**Re: Request advice on the Amendment Report for SSD-58978472 – Kelso Crescent
Multi-Level Warehouse, Moorebank**

Attachment A – Detailed Comments

Drawing Title:  
**Landscape Detail Plan 2**  
DWG No:  
**SSD-03**

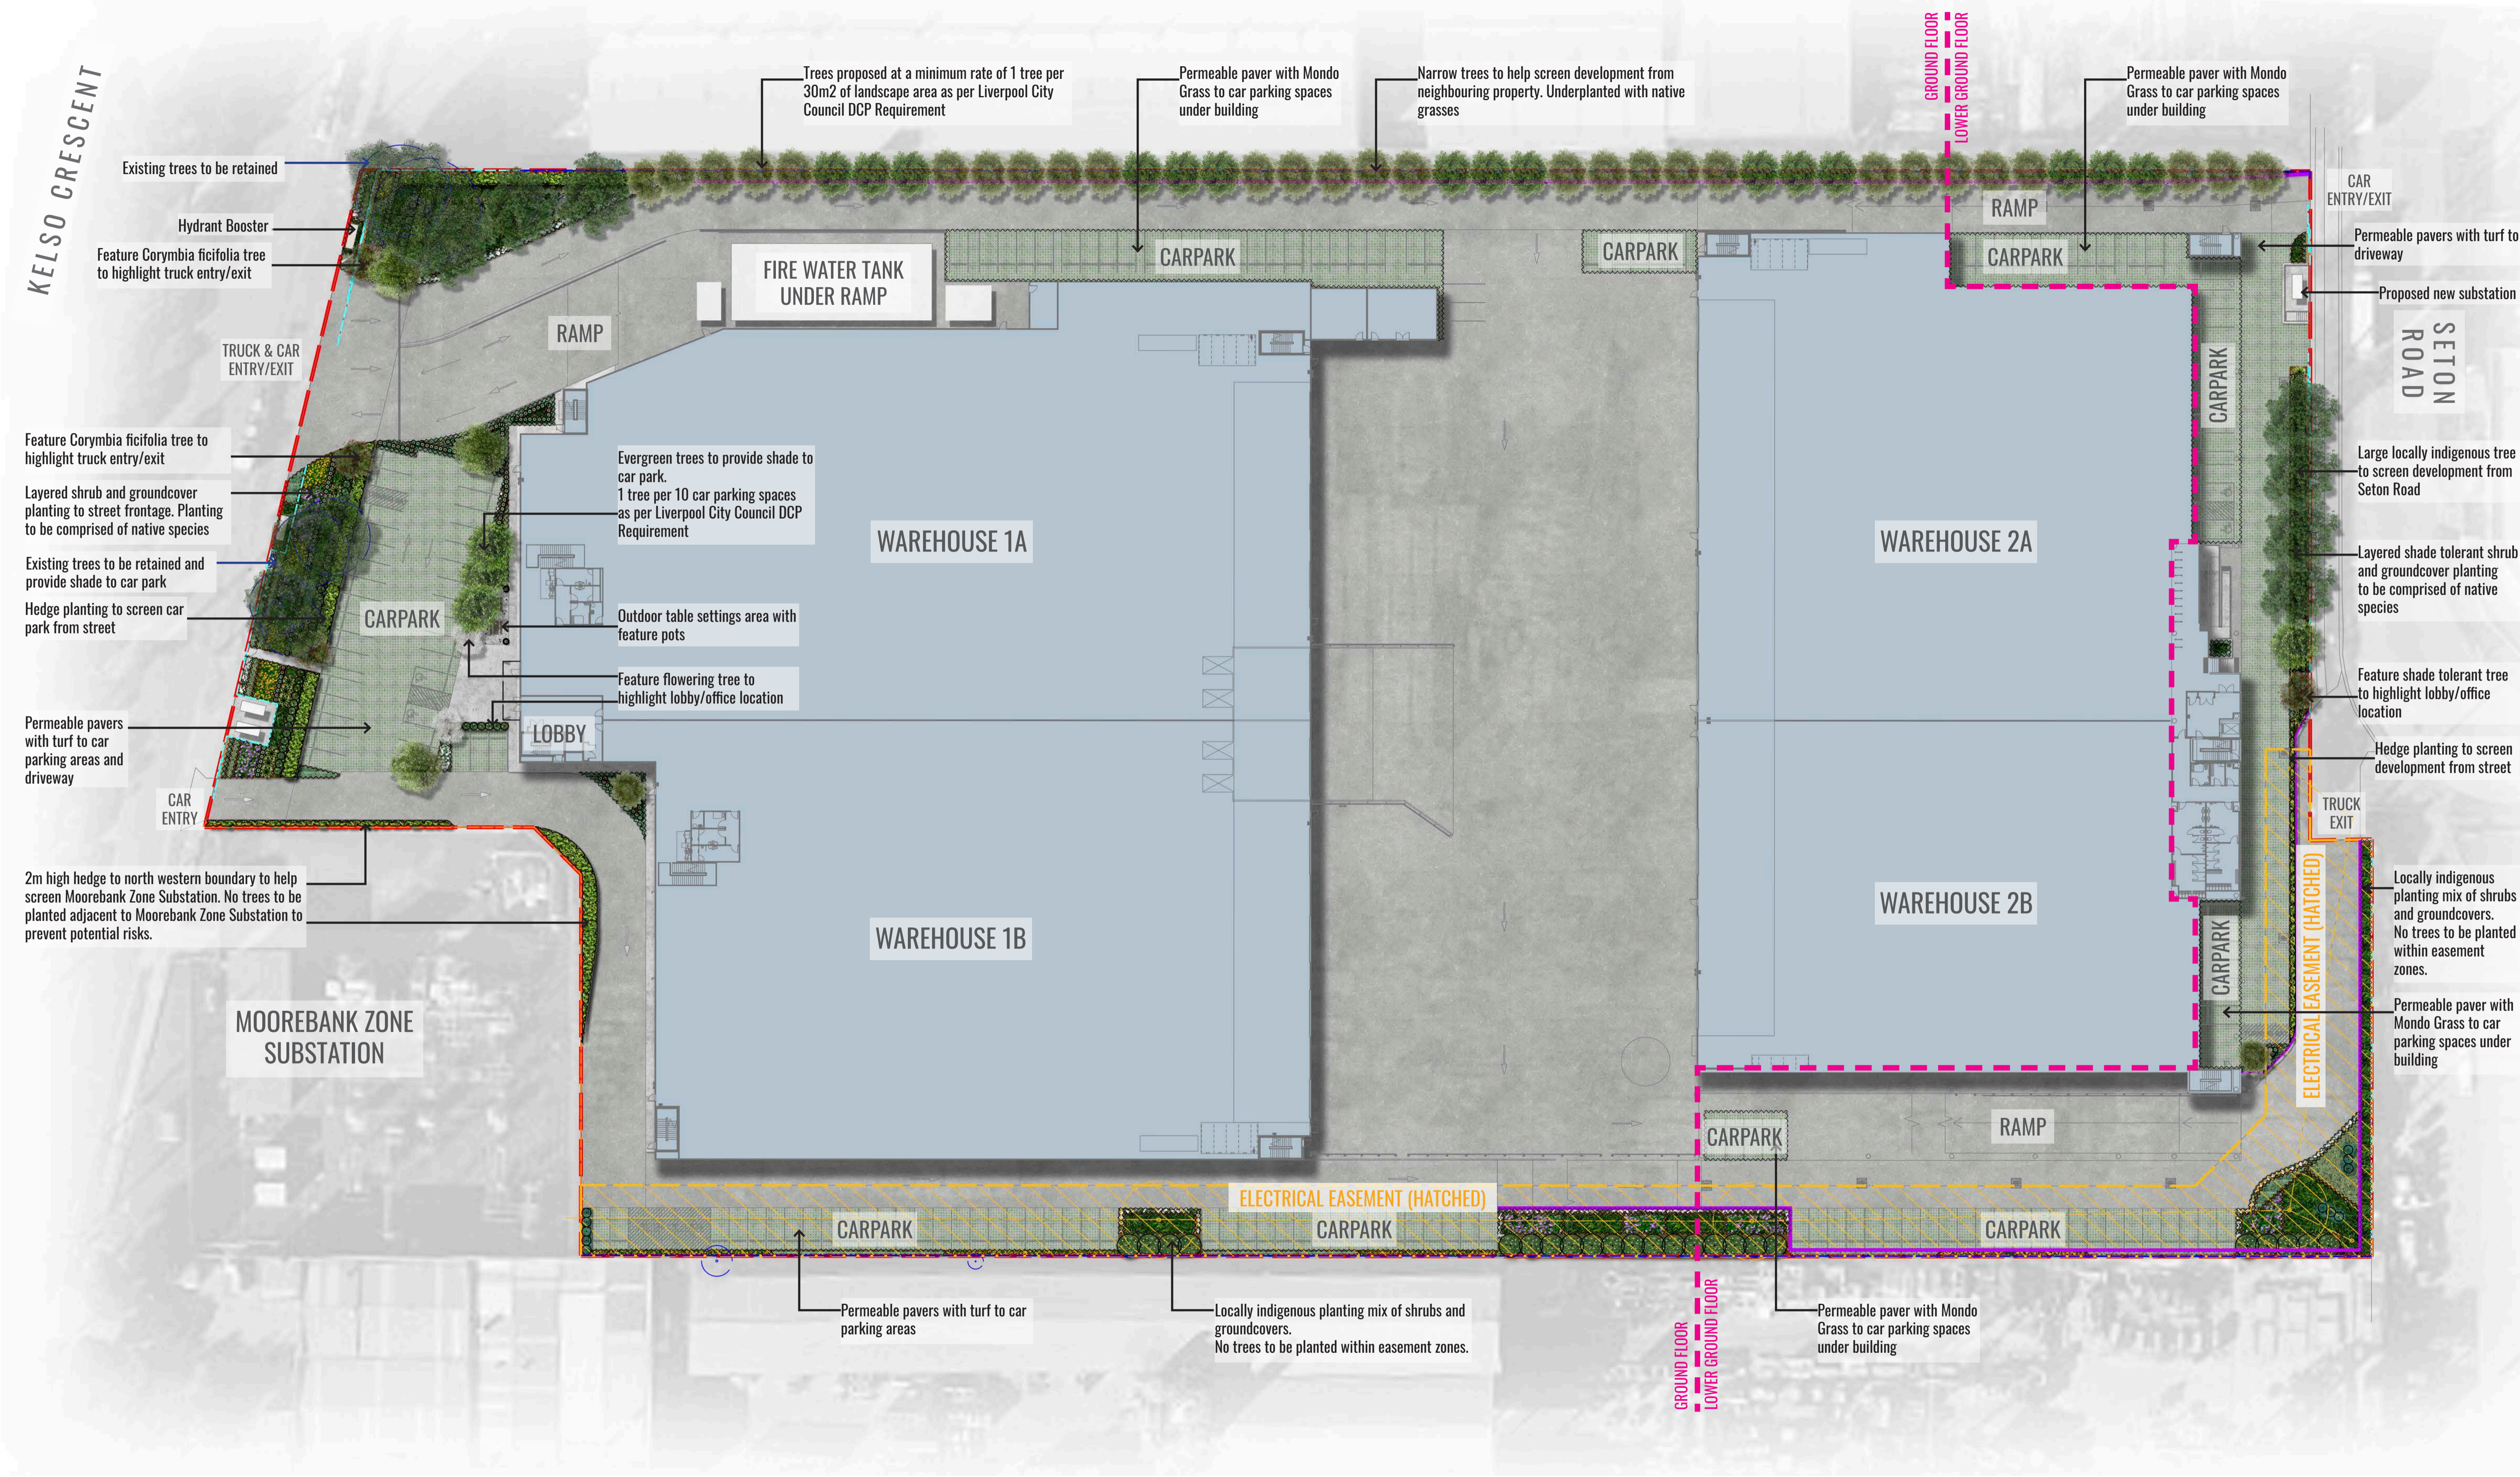
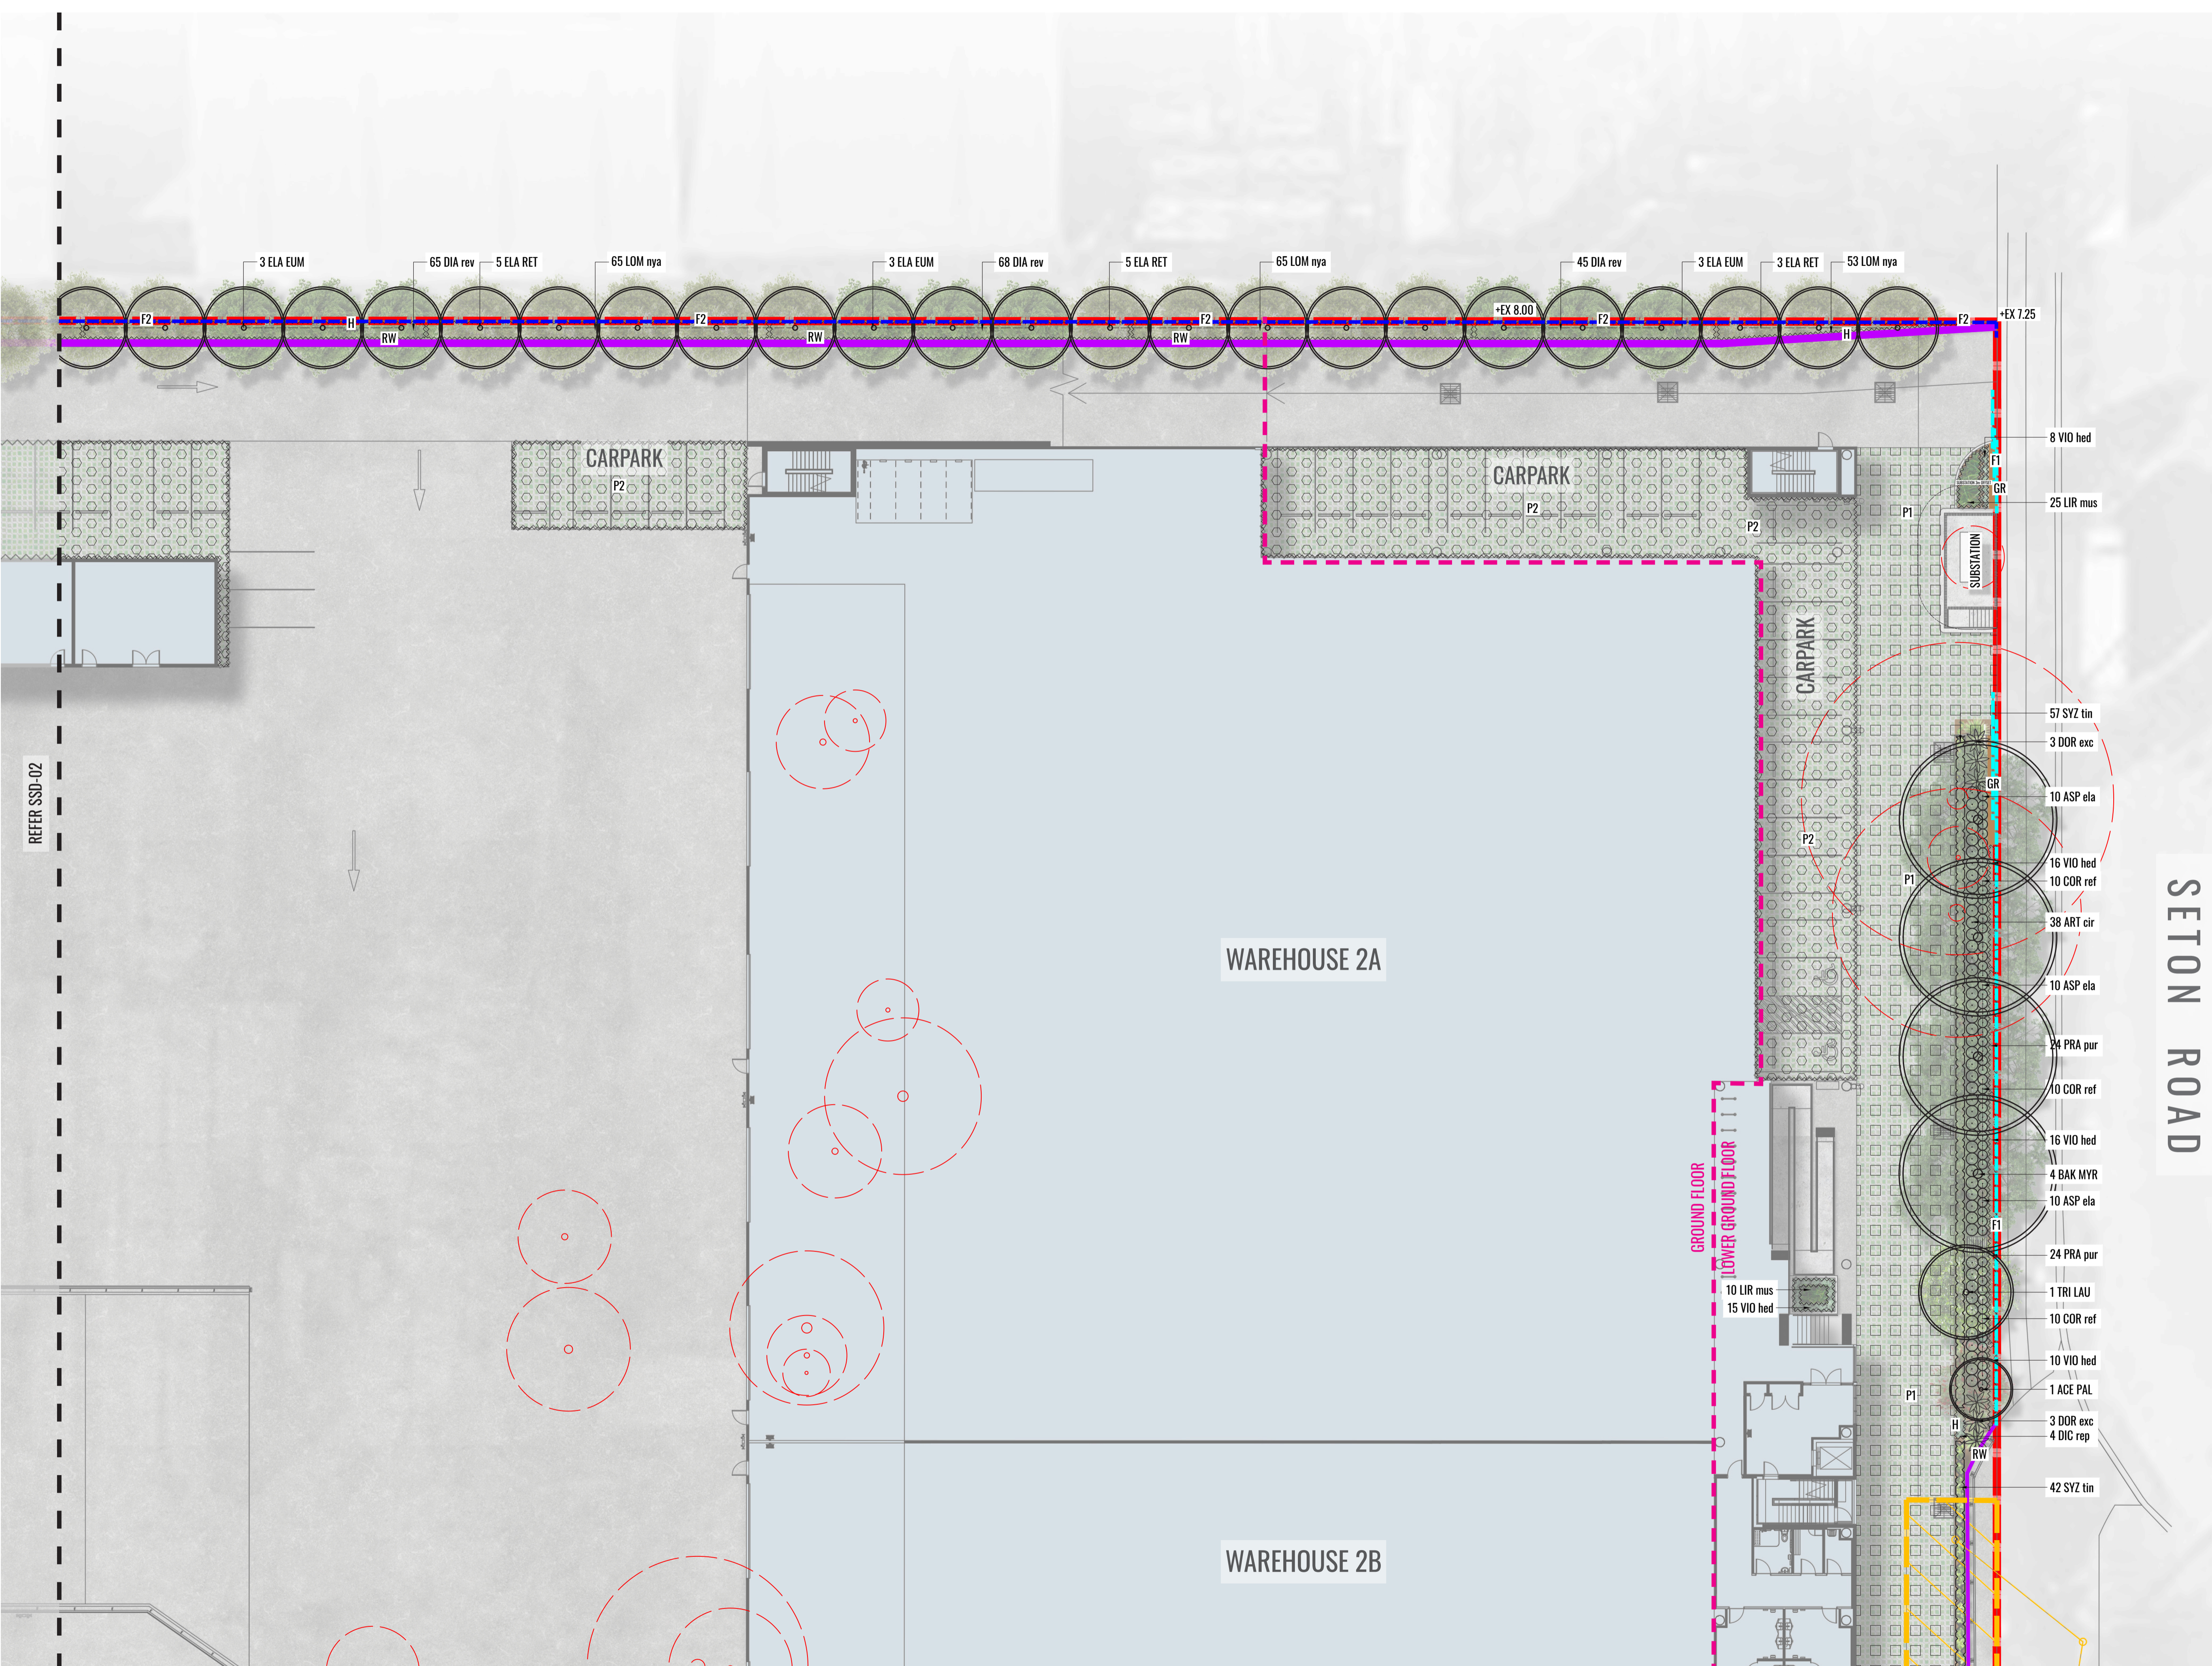
Tree Retention
 Several native, mature trees in good condition and within the front landscape setback and proposed to be removed (being: T15, T16, T17, T36 and T37), and this is not supported. Pot sizes should therefore be increased for several of the trees to a minimum 100L, and 200L for street trees, to reduce the time it will take for canopy to establish

These trees are all native, mature trees, all in at minimum good condition except for T16 which is 'fair' condition. T36 – the pedestrian entry could be reconfigured to keep.

Unclear why T15, T17 cannot be retained as well, now that T16 is being retained.

The Arborist report just states 'Remove' against these trees with no justification why.

Street trees have not been shown, these should be shown and pot sizes at 200L.

scale	As indicated	A1
project no	250211	
date	08.10.25	
dwn	dwg no	issue
DC	250211 - DA-112	A

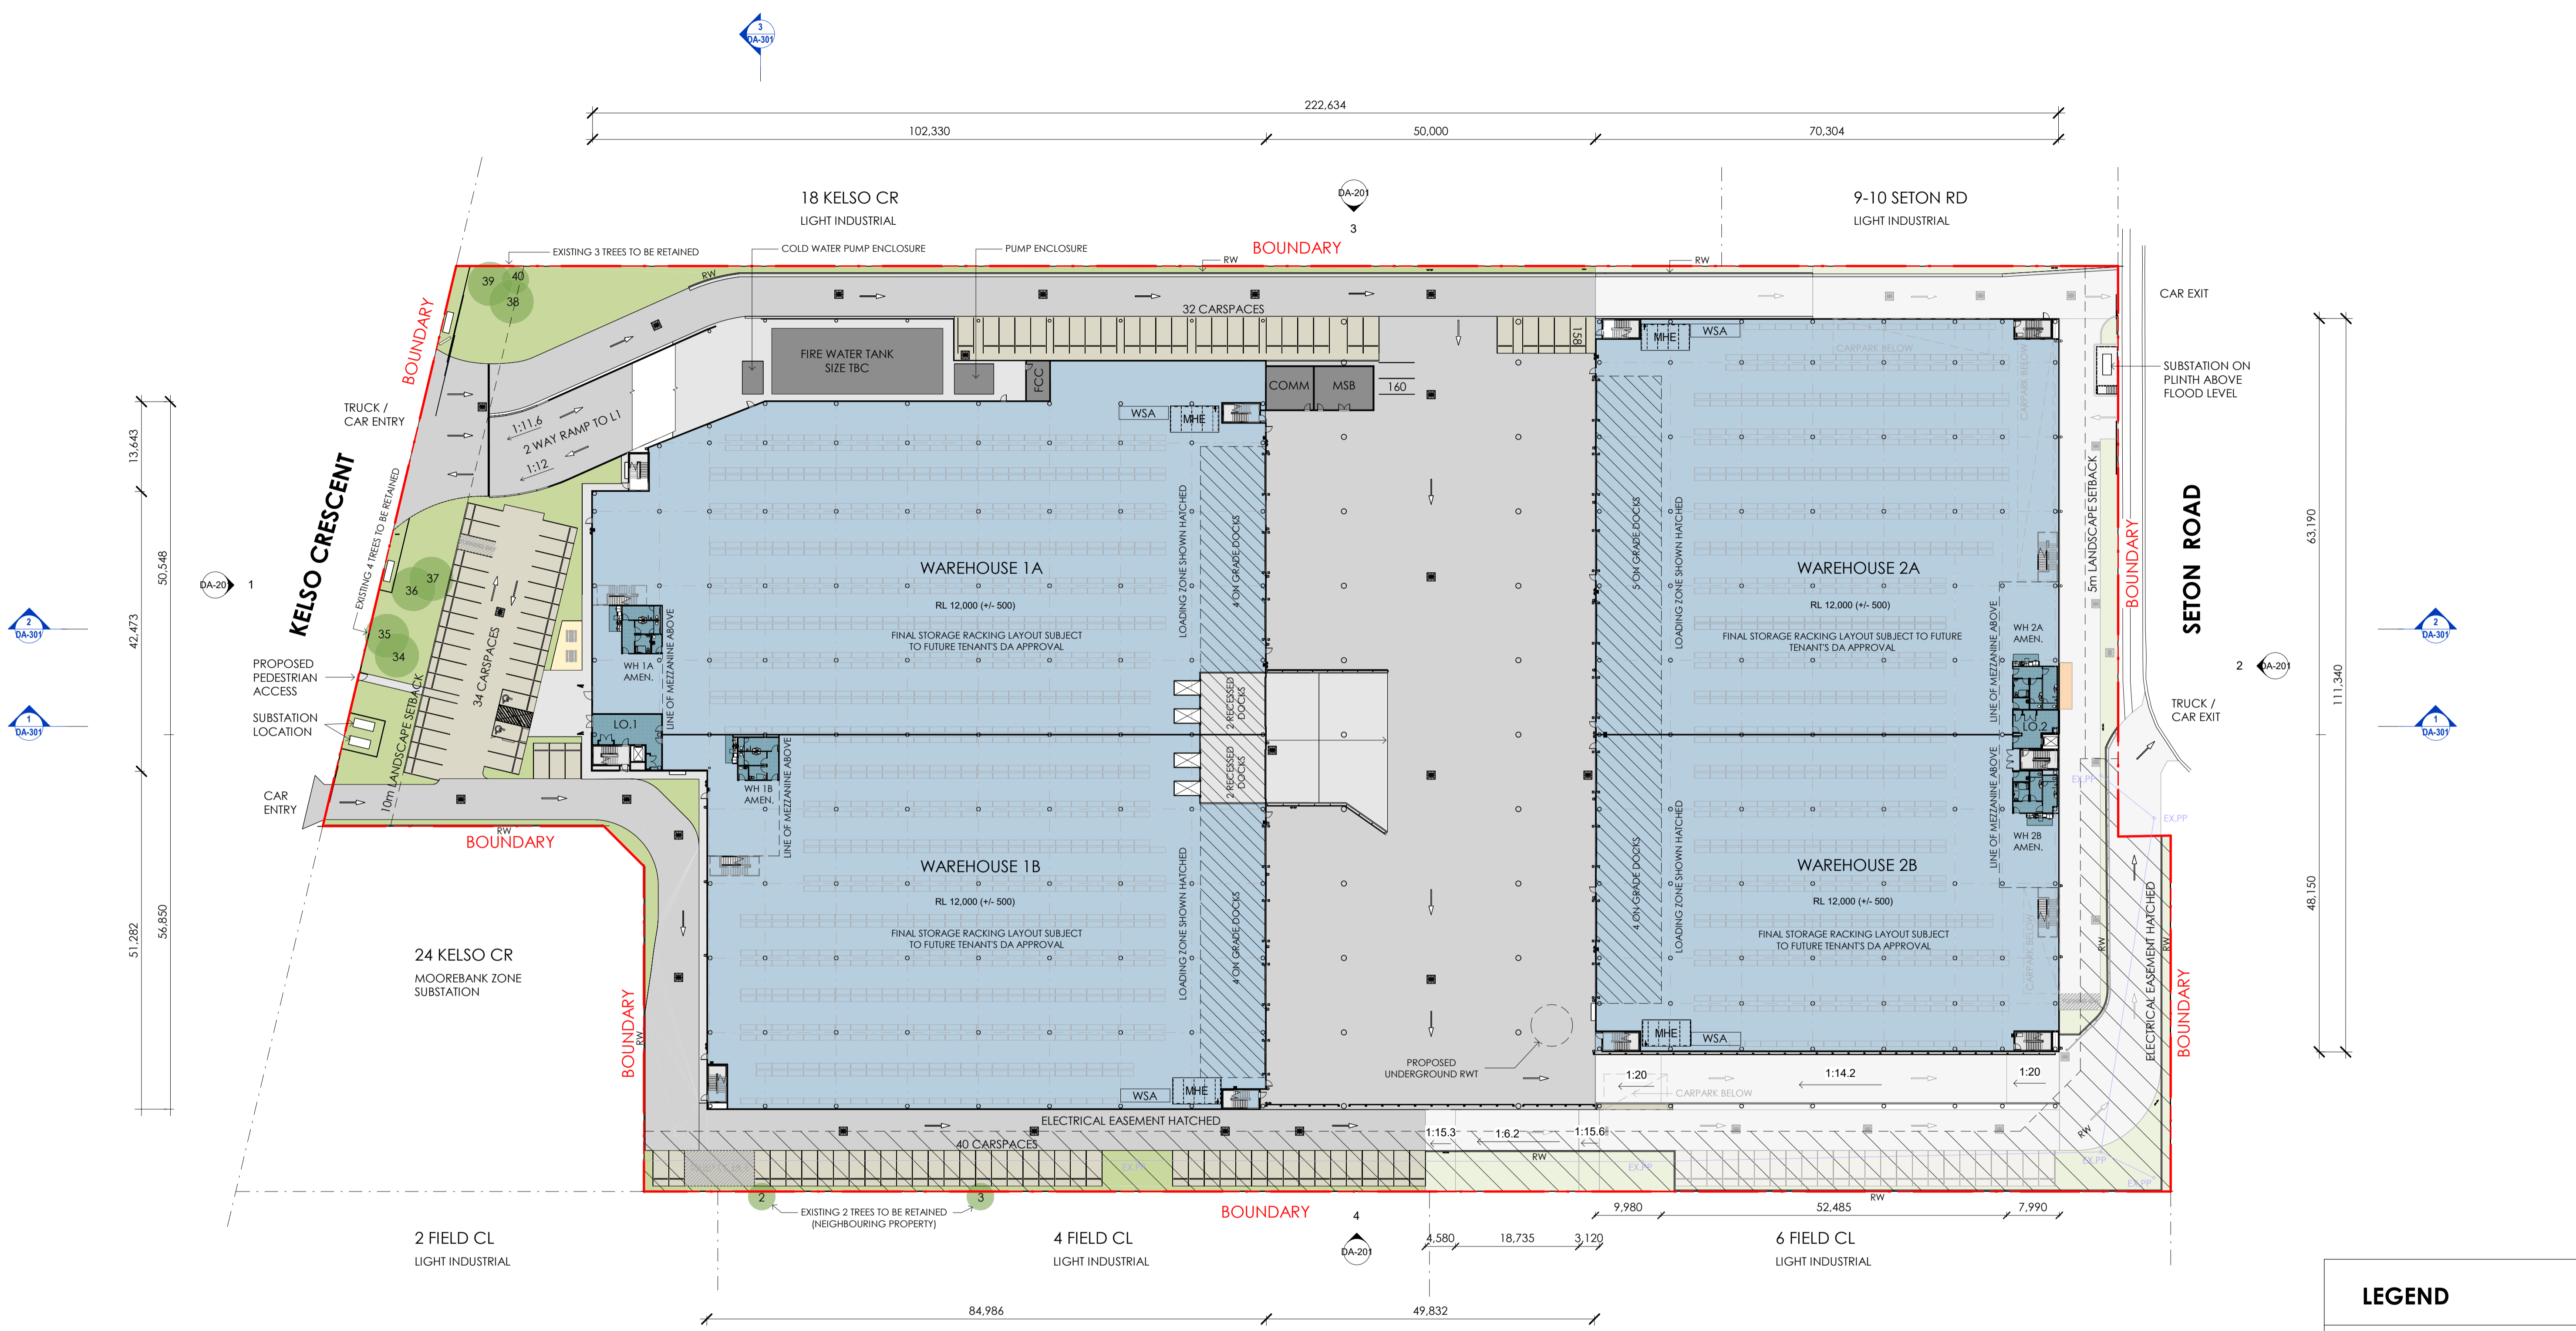
The Kelso Crescent car park entry is very close to the main pedestrian entry. Council recommends the applicant increases the separation between both entries to improve safety for pedestrians. Council is supportive of the external terrace to the office space, however, seeks clarity as to whether it is accessible to all staff or just those working in the adjacent office. The applicant should demonstrate that all staff frequenting this development have access to good quality communal space

The car park and entries are not separated by 8m landscaped as described.

The distance/dimension in question is illustrated below and appears to be 2-3m.

Not addressed. While the pedestrian entry is not far from the driveway, it runs straight through the car park. This is not a safe or appropriate way to enter a main entry of a building, through a car park. **The main entry foot path should be reconfigured to enable a direct connection to the main entry, with enough separation from the driveways and not having to walk through a car park and conflict with vehicles.**
